App no: 21.0437

Address: 67 Hillcrest Road Langho

Proposal: Regularisation of erection of 1.8m high garden fence to boundary along with laurel hedging to screen fence and planning permission for a detached garden building. Resubmission of 3/2021/0130

Proposed Site Plan

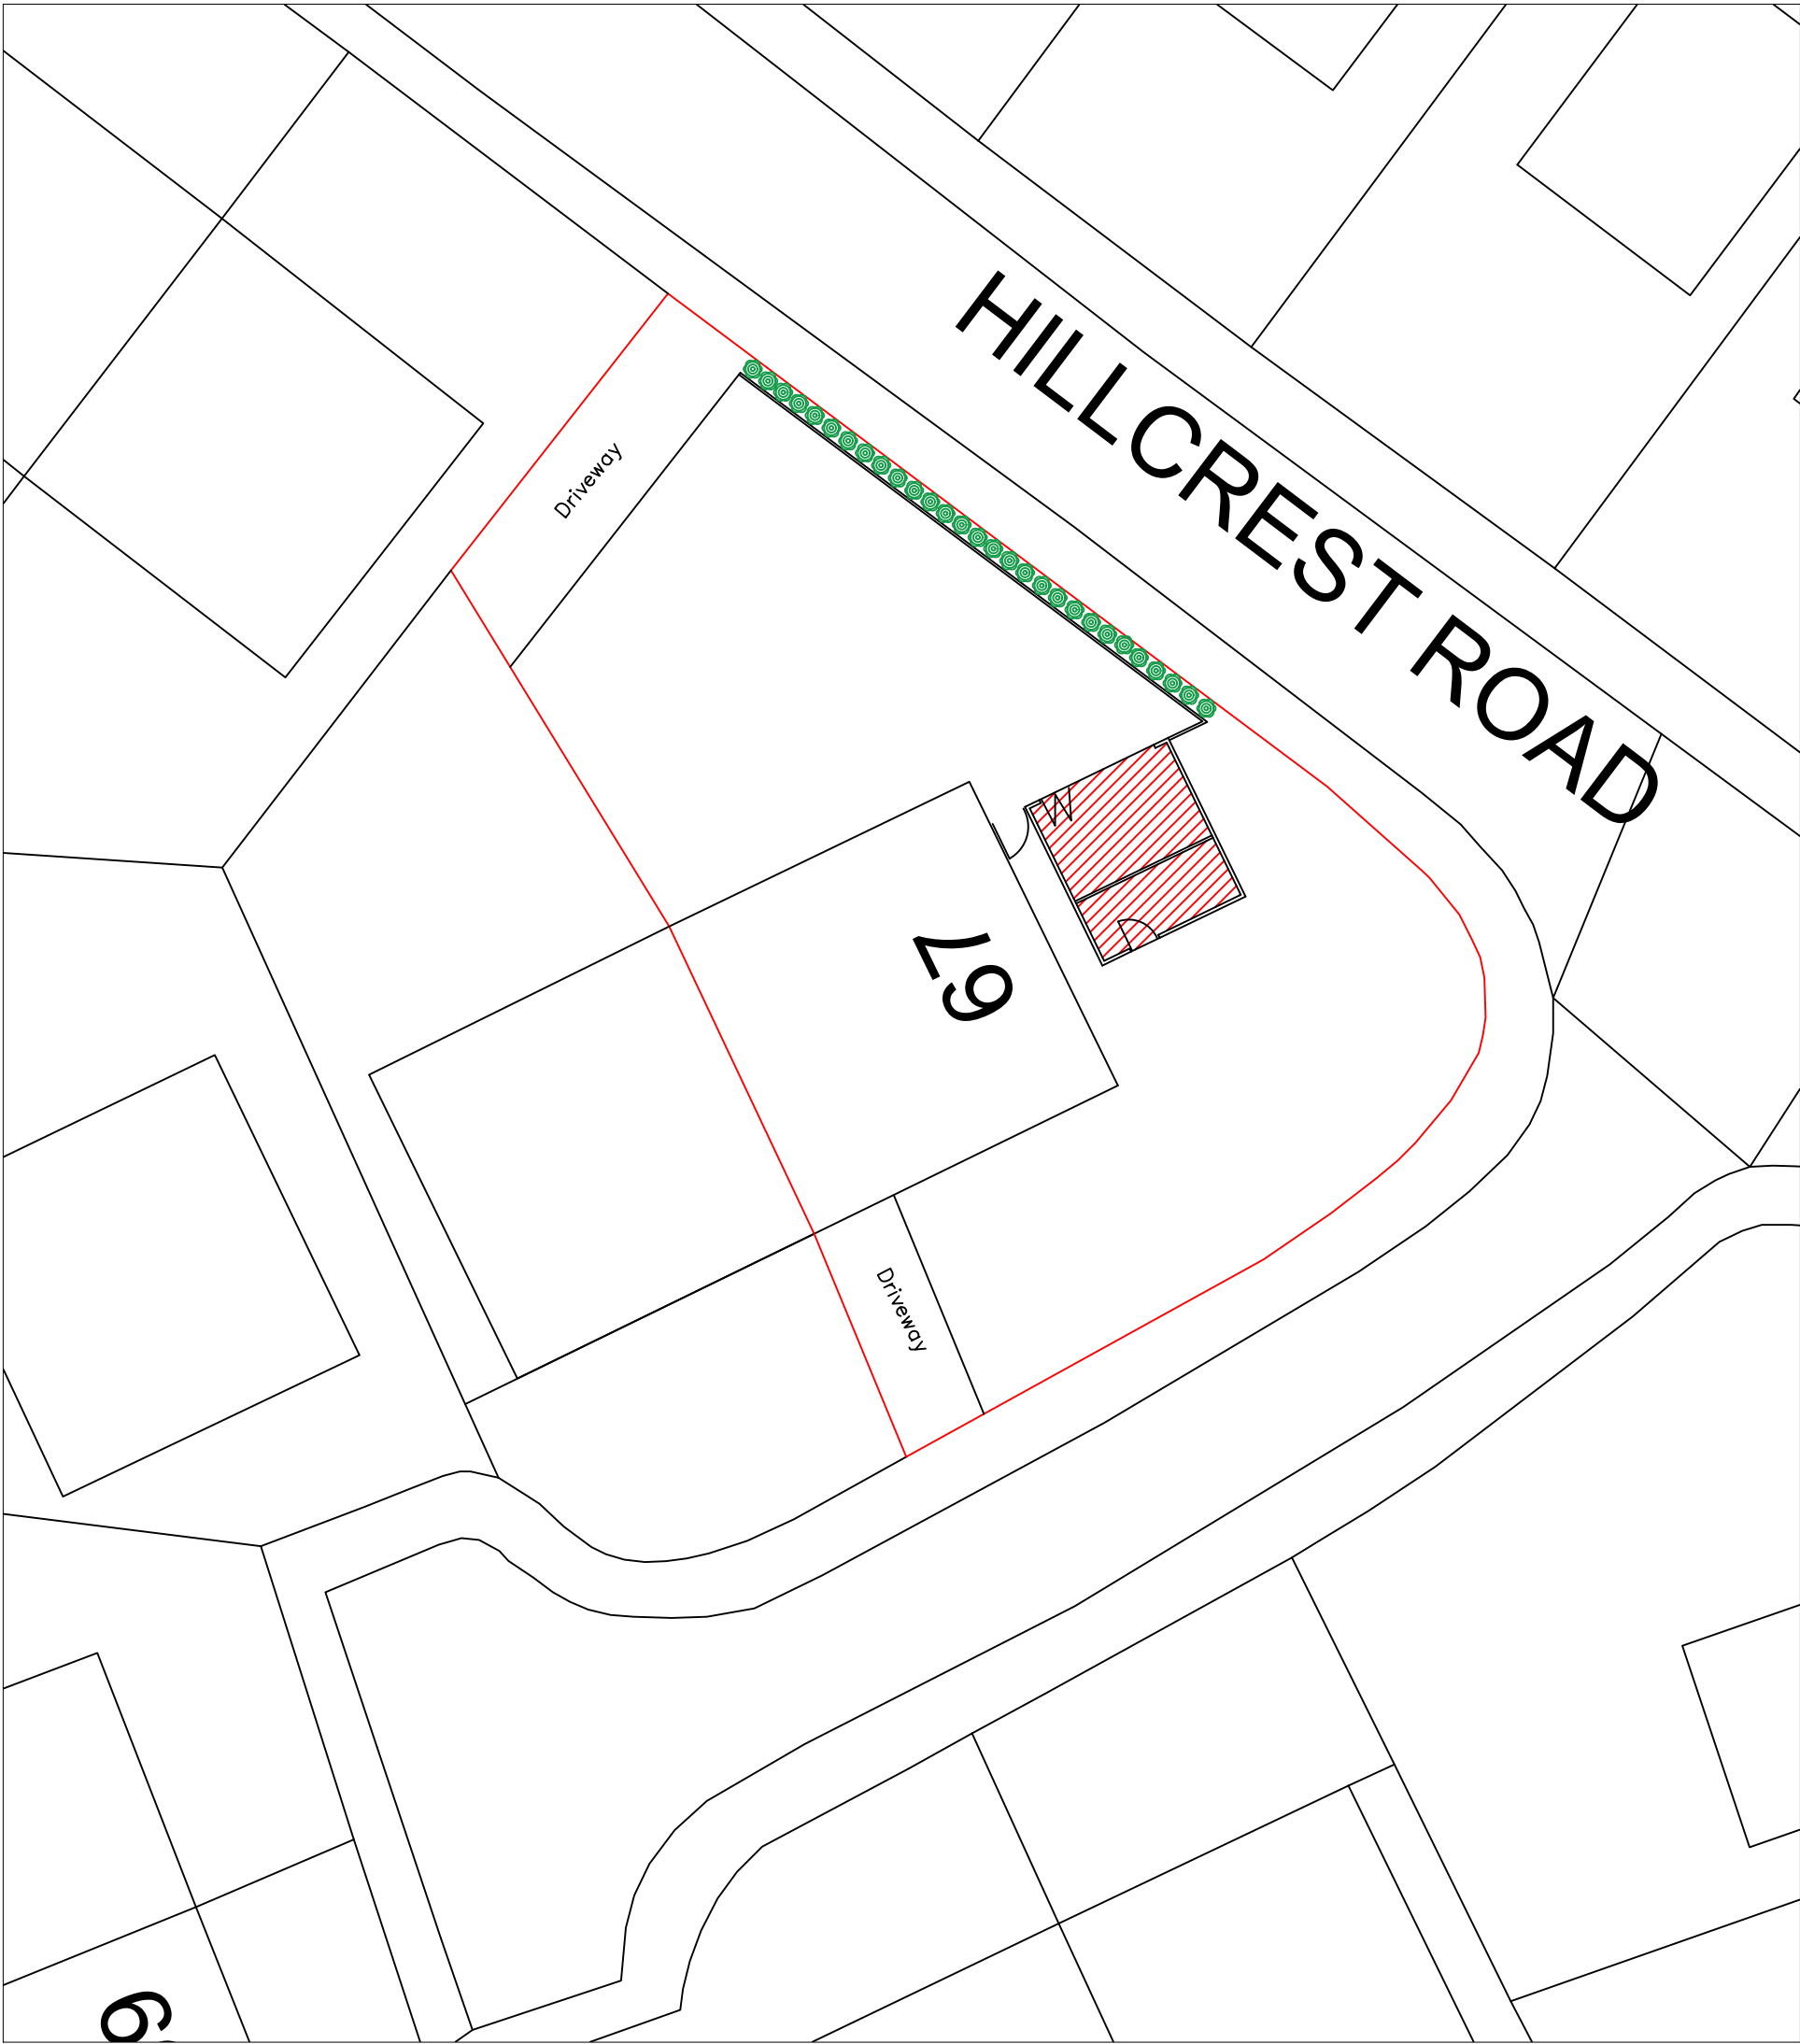
There are a number of points which I would like to highlight to the applicant which includes that the new driveway should be paved in a porous bound material and remain ungated. A vehicle crossing is required on Hillcrest Road to allow vehicles to traverse the footway and the applicant must contact Lancashire County Council on the website using the following link:- <http://new.lancashire.gov.uk/roads-parking-and-travel/roads/vehicle-crossings.aspx> to obtain a quotation and request the works.

The existing vegetation along the boundary of Hillcrest Road is overhanging the footway on certain sections and this needs to be trimmed back to ensure that the visibility splays at the road junction are maximised and that pedestrians can use the full width of the footway especially when vehicles are parked on street and partly blocking the footway.
